Response to: Consultation Response from KC Environmental Health – Pollution & Noise Control

Application: 2020/90450

Site: Land at, Owl Lane, John Ormsby V C Way, Dewsbury, WF12 7RQ

Proposal: Erection of restaurant with drive-thru, car parking, landscaping, play frame, customer order displays and associated works.

Site Plan Drg No. 7866-SA-8587-P004B

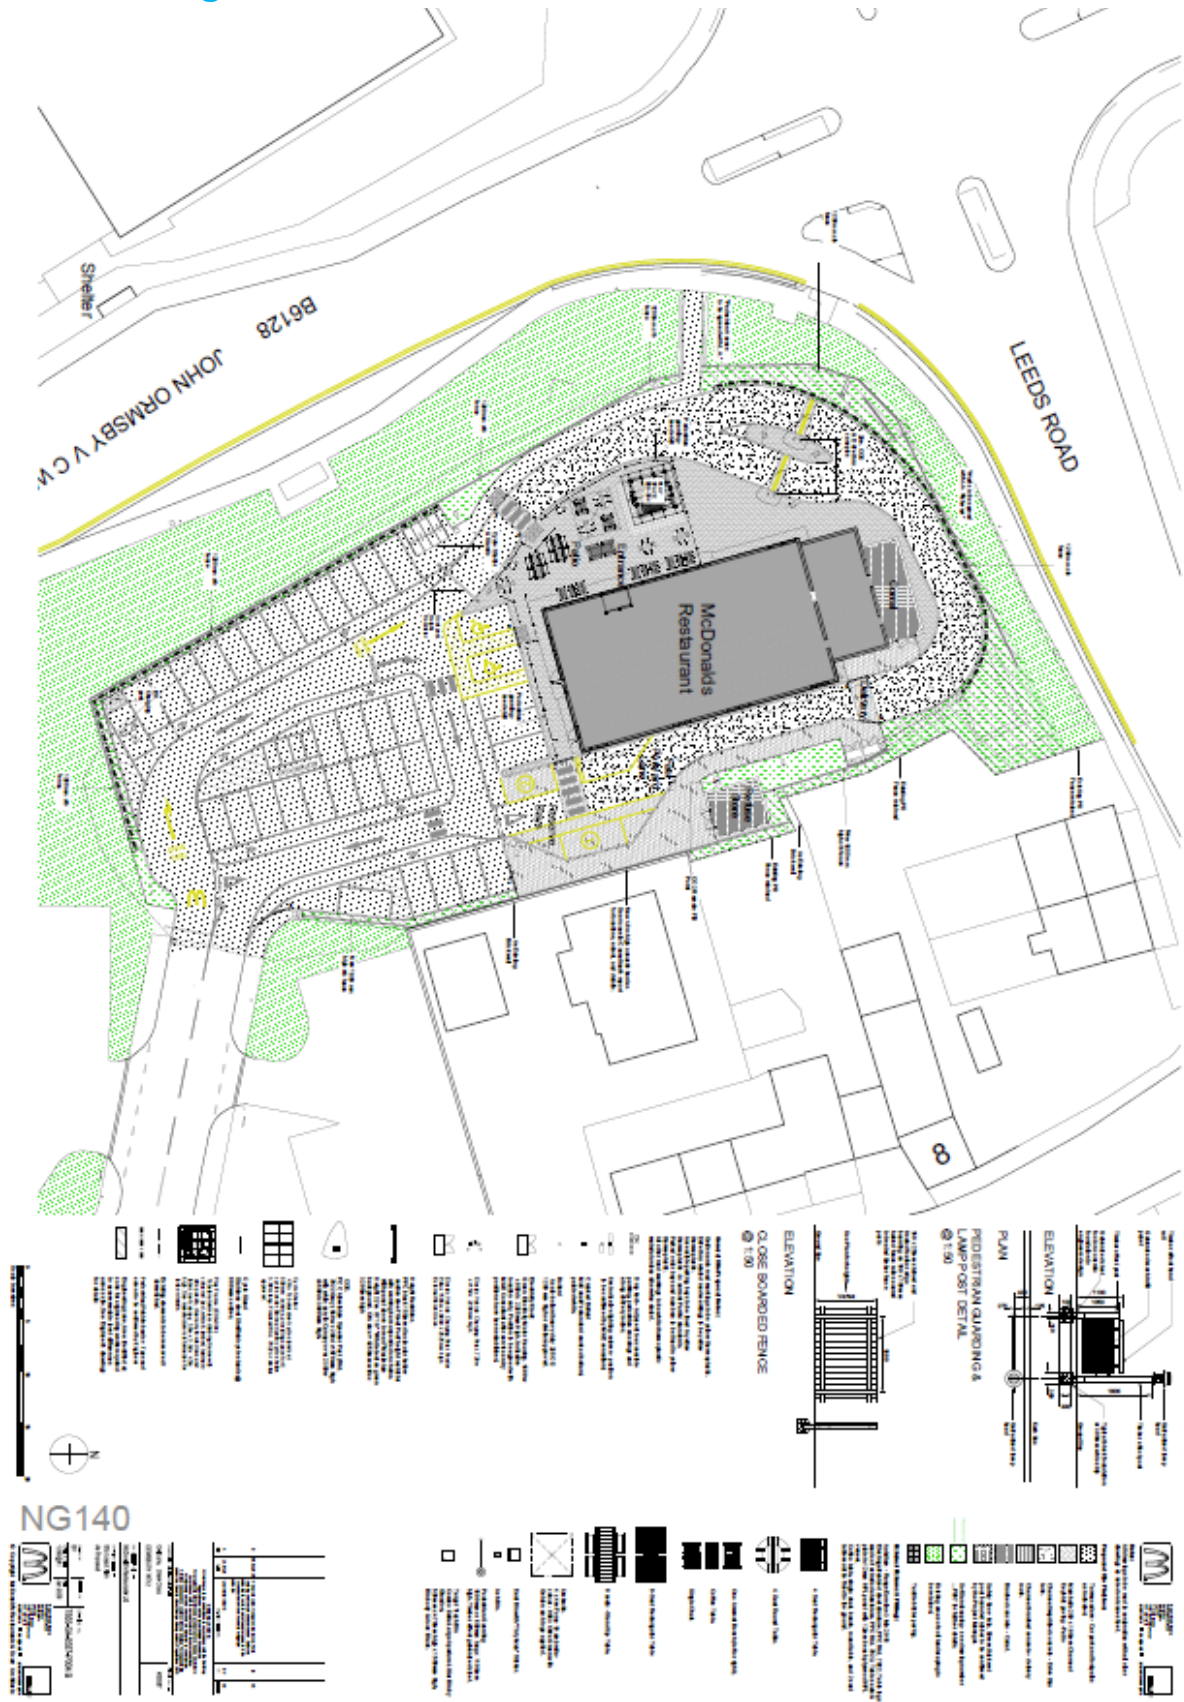
Please find attached the revised drawing 7866-SA-8587-P004C Proposed Site Layout Plan (1), which shows a total of 4No EVCP on site, in line with policy and compliance with the condition.
